PCU061254

Your reference: SSD-5850
Our reference: DOC15/301439-1
Contact: Robert Gibson, 4927 3154

RE: MOUNT OWEN CONTINUED OPERATIONS PROJECT (SSD-5850) – RESPONSE TO SUBMISSIONS REPORT

ATTACHMENT 1: OEH COMMENTS ON THE RESPONSE TO SUBMISSIONS REPORT FOR THE MOUNT OWEN CONTINUED OPERATIONS PROJECT (SSD-5850)

**Figure 2C:** Project Layout – Hebden Road Upgrades

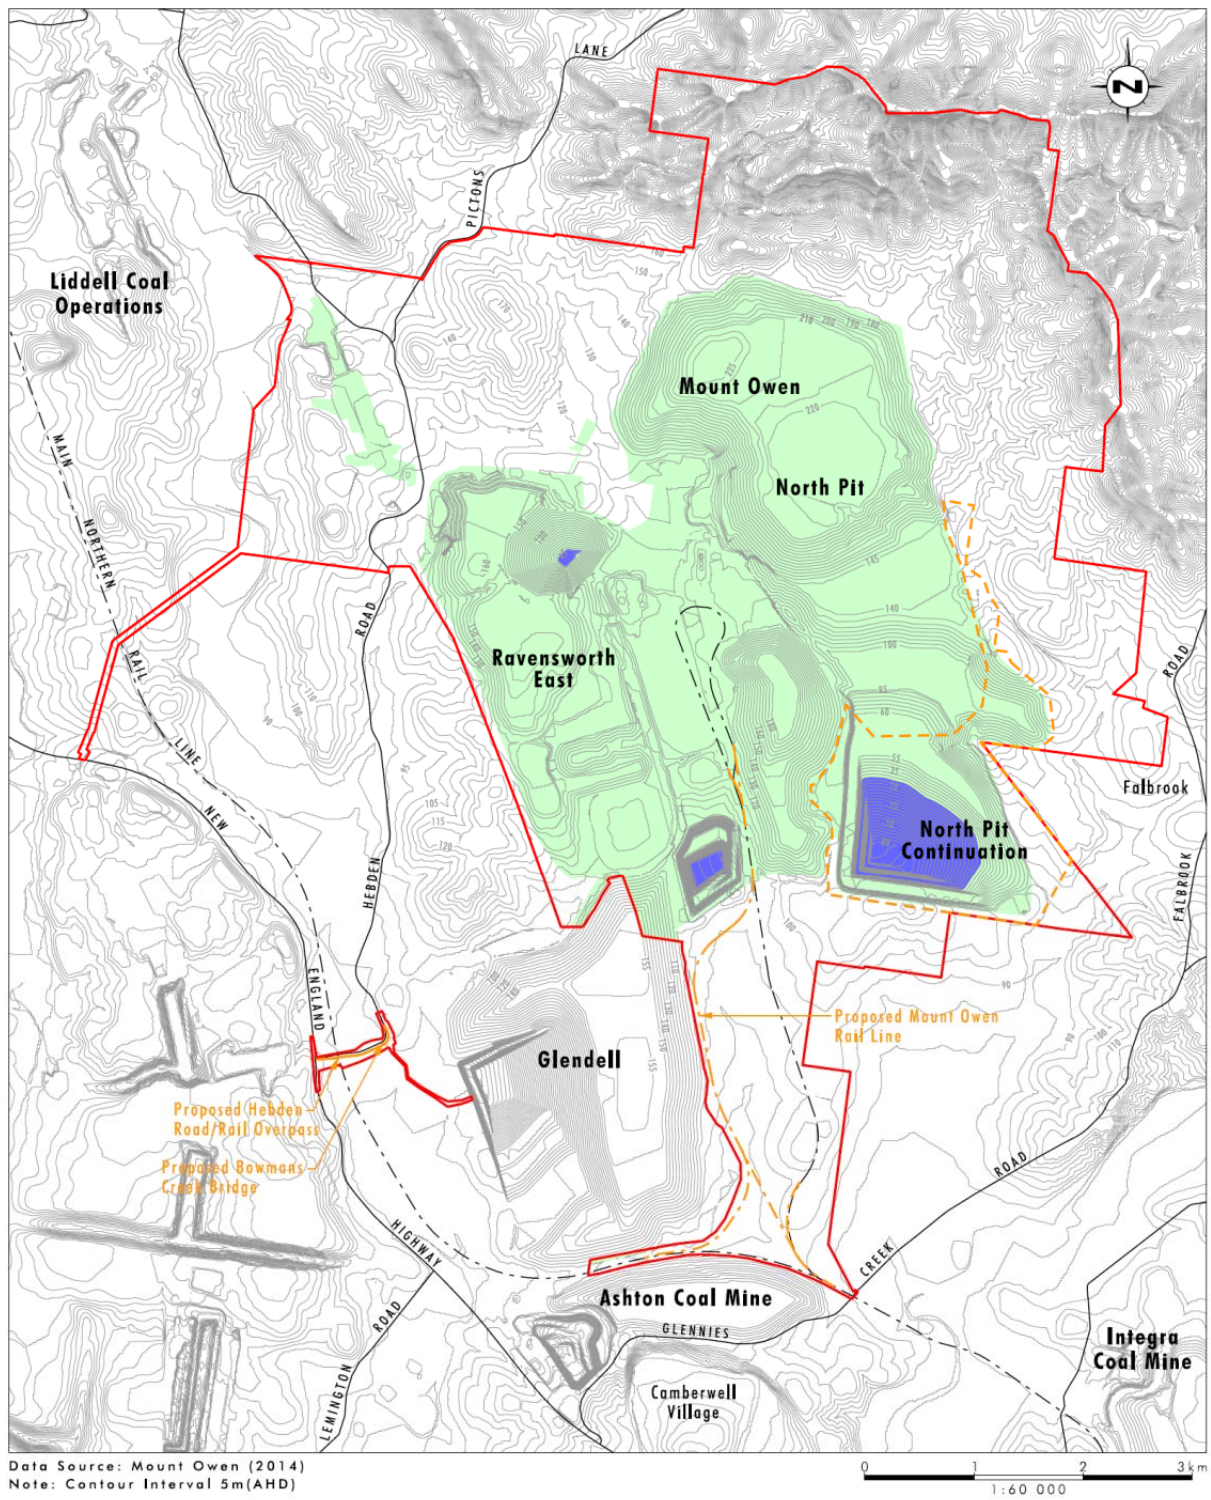
- Increase in depth, hazard category and duration of inundation for the Hebden Road crossing of Yorks Creek.

Hebden Road is a public road. Any adverse change to existing depth or period of inundation of this roadway provides an increased risk to road users and the emergency services in flood events. The proponent is required to demonstrate no additional adverse effects on public infrastructure as a result of the development.

An on-site detention pond and additional culverts under Hebden Road were previously approved to mitigate the effect of increased flows in Yorks Creek and on Hebden Road for the existing approved development

footprint. The design of these items should be updated to ensure that there is no increase in depth or duration of inundation of Hebden Road for events up to and including the 1% Annual Exceedance Probability (AEP) event as a result of the proposed additional development. Review of the design could make it possible to ensure that a condition of no increased offsite impacts are met.

**Figure 5B: Additional On-site Biodiversity Offset Areas**

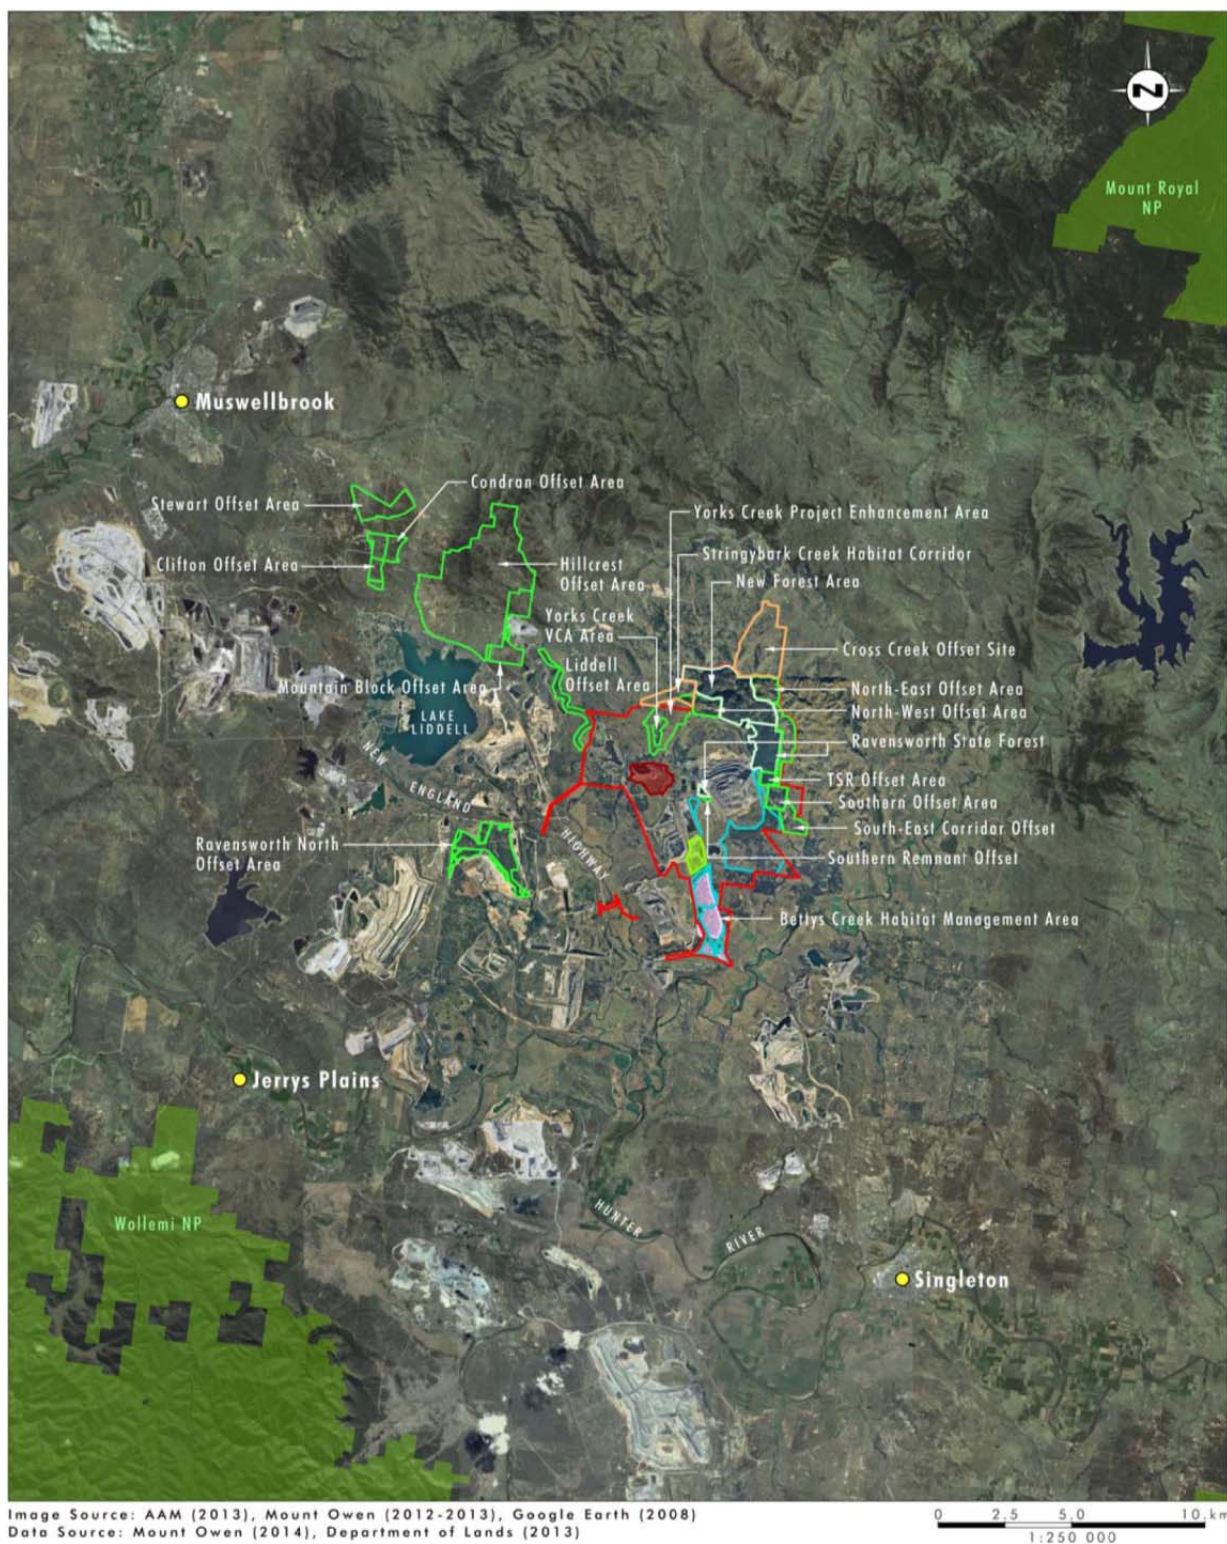
In applying the FBA to this project OEH made several assumptions (provided in OEH's letter dated 11 March 2015) in order to run the BioBanking Credit Calculator – this data was not provided in the EIS nor in the RTS report (see Table 20 in the FBA for a list of required data). OEH's assessment found that the offset package generated fewer ecosystem credits and species credits than the development site. That is despite the offset package being more than twice the size of the development site (see **Table 1**, below).

By applying the FBA trading rules for ecosystem credits within the same vegetation formation, and allowing for the use of credits generated from Plant Community Types (PCTs) less cleared than the vegetation in the development site, there is a credit shortfall of about 18,241 credits (see **Table 3** below).

OEH notes that the proponent does not own land along the central reach of Stringybark Creek that is within the assessment area for this project and thus they are unable to implement rehabilitation along additional parts of this creek for use by the Spotted-tailed Quoll. Therefore, OEH recommends that additional effort is required to put back a larger assemblage of indigenous species in the revegetation and rehabilitation components of the offset package, as was touched on in our letter dated 11 March 2015.

1. That all of the biodiversity offset land as described in the Environmental Impact Statement for the Mount Owen Continuation Project must be secured within 12 months of any consent being granted by an appropriate conservation mechanism that is applicable under current biodiversity offsetting policy.
